May 19, 2021

**Re: SUB20-002 (Cheshire Short Plat) Final Plat Request for Information 1,
7615 E Mercer Way
Core Project Number: 19205**

The purpose of this letter is to provide a response to the review comments for the Cheshire Short Plat project review dated May 10, 2021. We have addressed each comment and revised the plan/documentation accordingly. This letter contains the review comments immediately followed by our response to each in bold lettering.

CHESHIRE SHORT PLAT

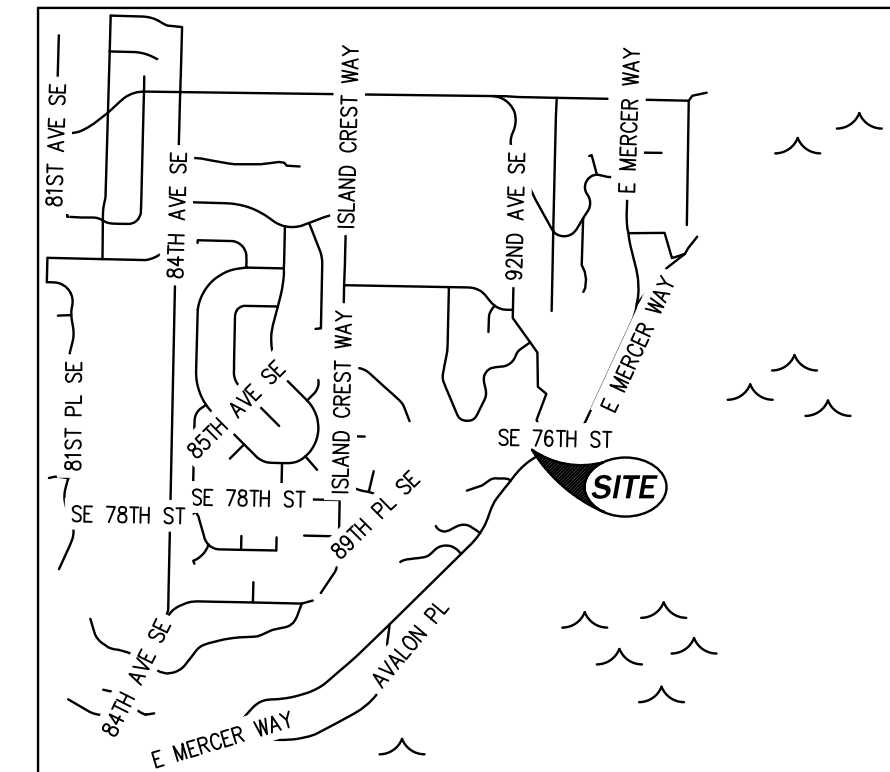
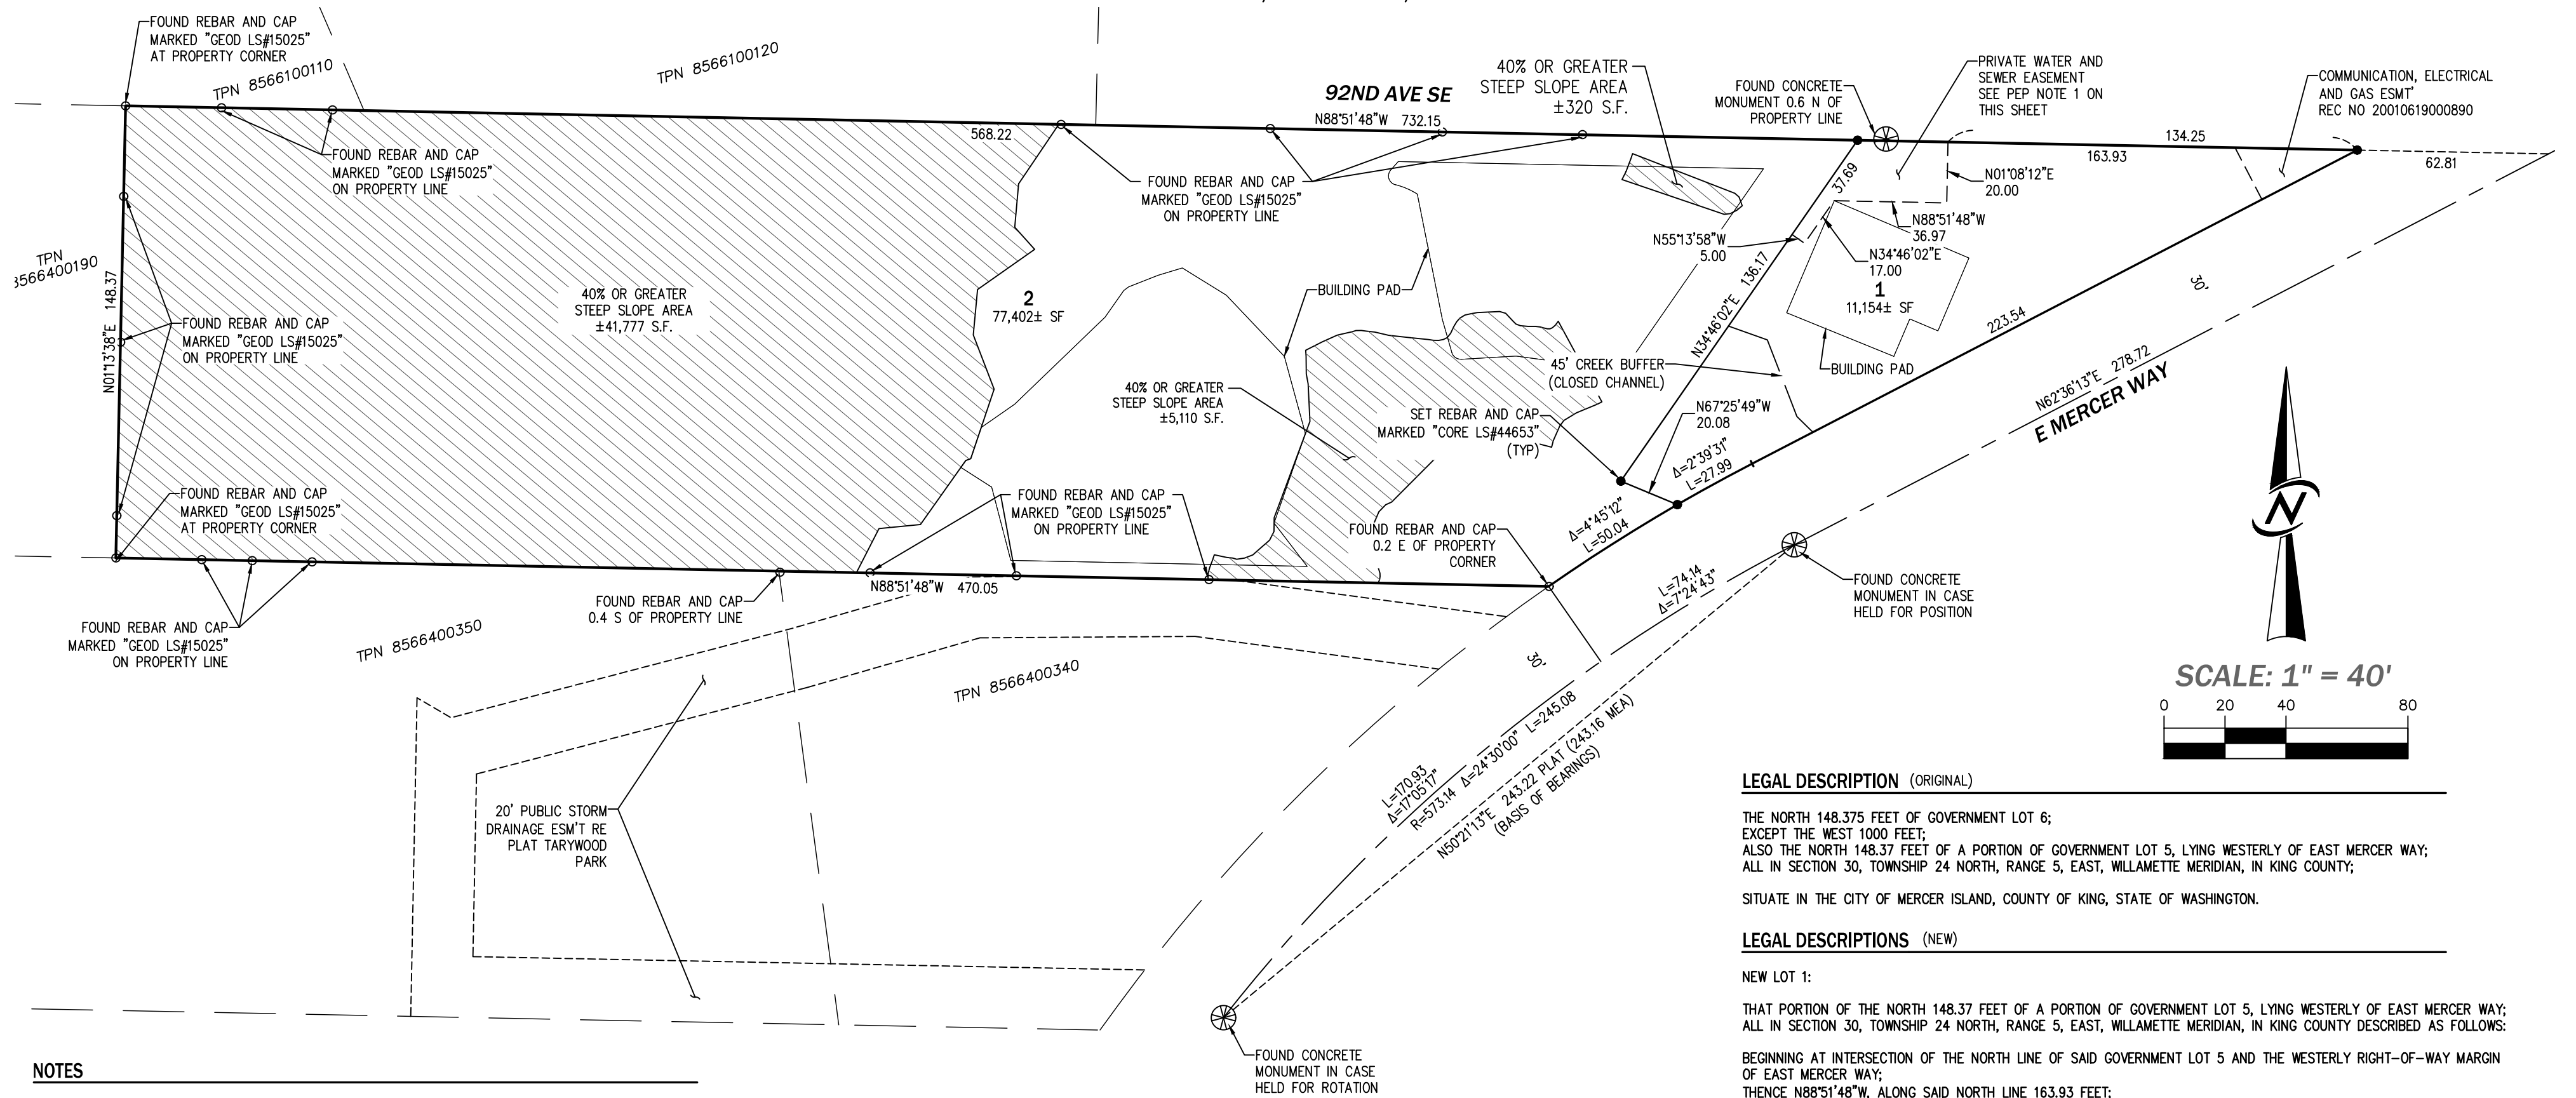
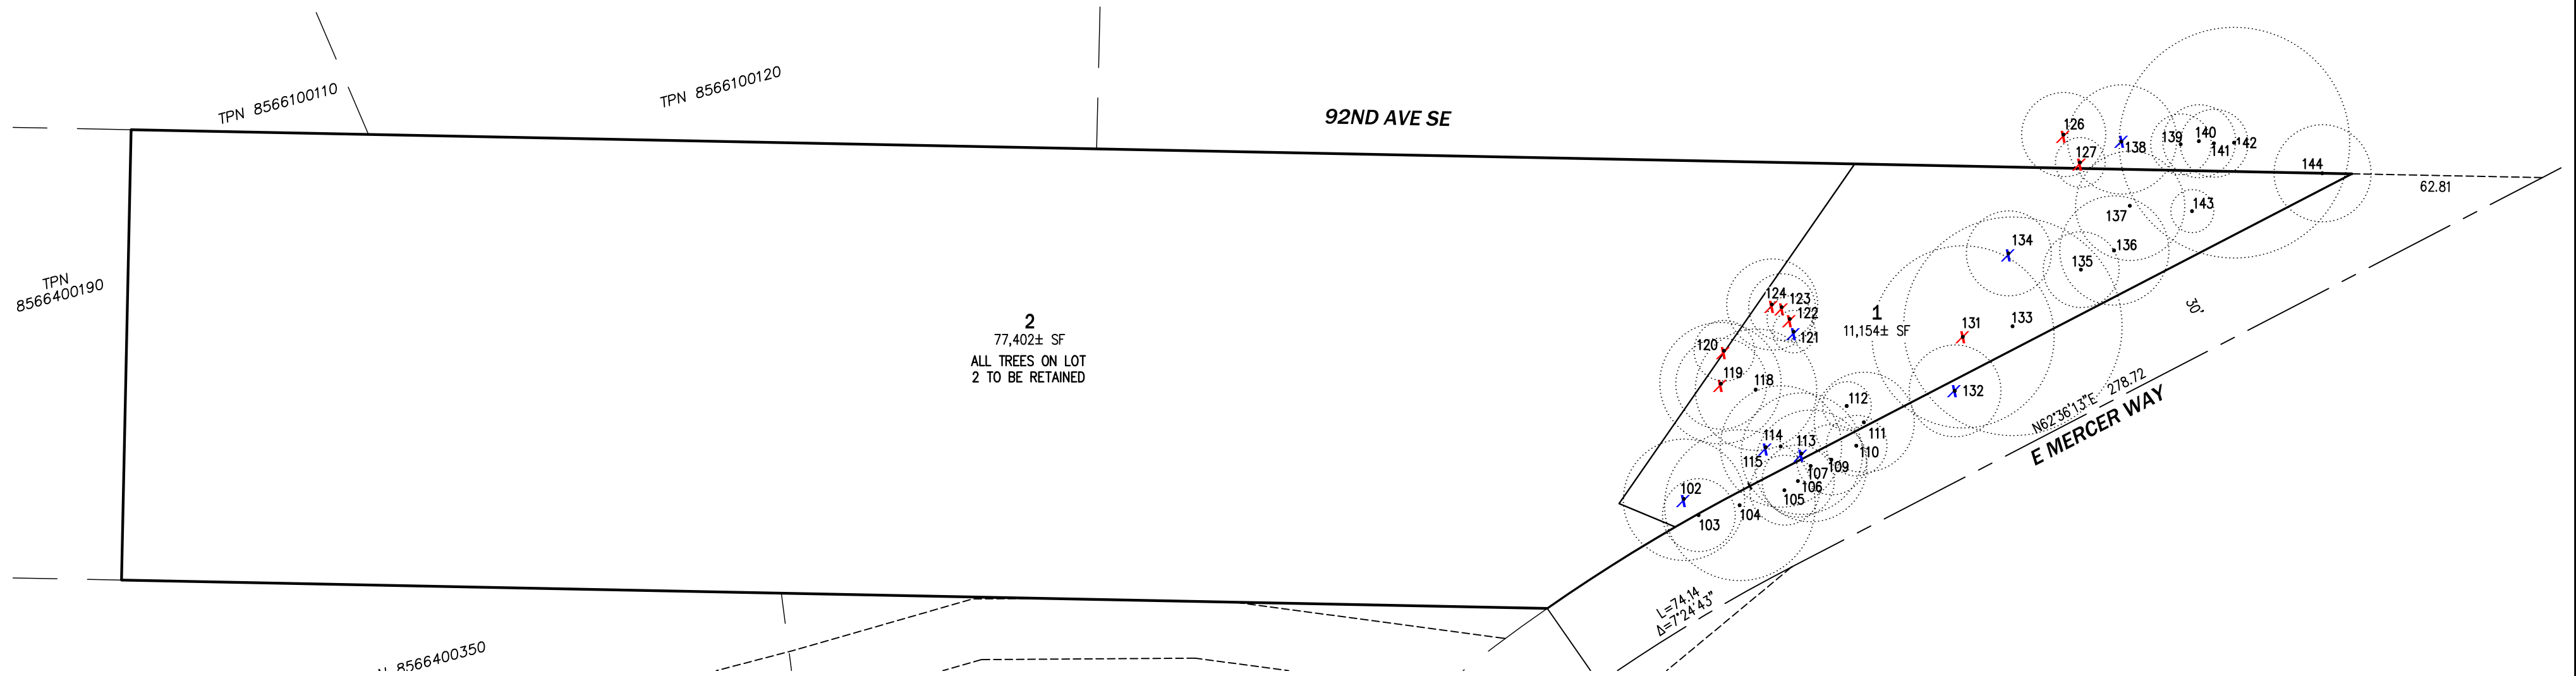
1. Please show showing the location of critical areas on the face of the plat, pursuant to MICC 19.08.050(C)(2)(k).

2. Please show the approved building pads on the face of the final plat, pursuant to MICC 19.08.050(C)(2)(m).

4. Please add conditions 3, 4, and 10-14 from the preliminary approval to the face of the final plat.

1. Please include the plan showing numbered, retained trees and building pads as part of the final plat. This plan should be the same or consistent with the Preliminary Tree Plan approved with the preliminary short subdivision approval.

1. Please place the following note on the face of the final plat: "All building permits are subject to meeting current fire code requirements at the time of a complete submittal, including fire apparatus access as outlined in adopted code sections of the International Fire Code Appendix D. Fire plan reviews will be conducted at time of building permit submittal and may require additional fire protection systems and/or additional fire prevention measures for building approval."

Response: Revised as requested.

Response: Revised as requested.

Response: Revised as requested.

Response: Revised as requested.

Response: Revised as requested.
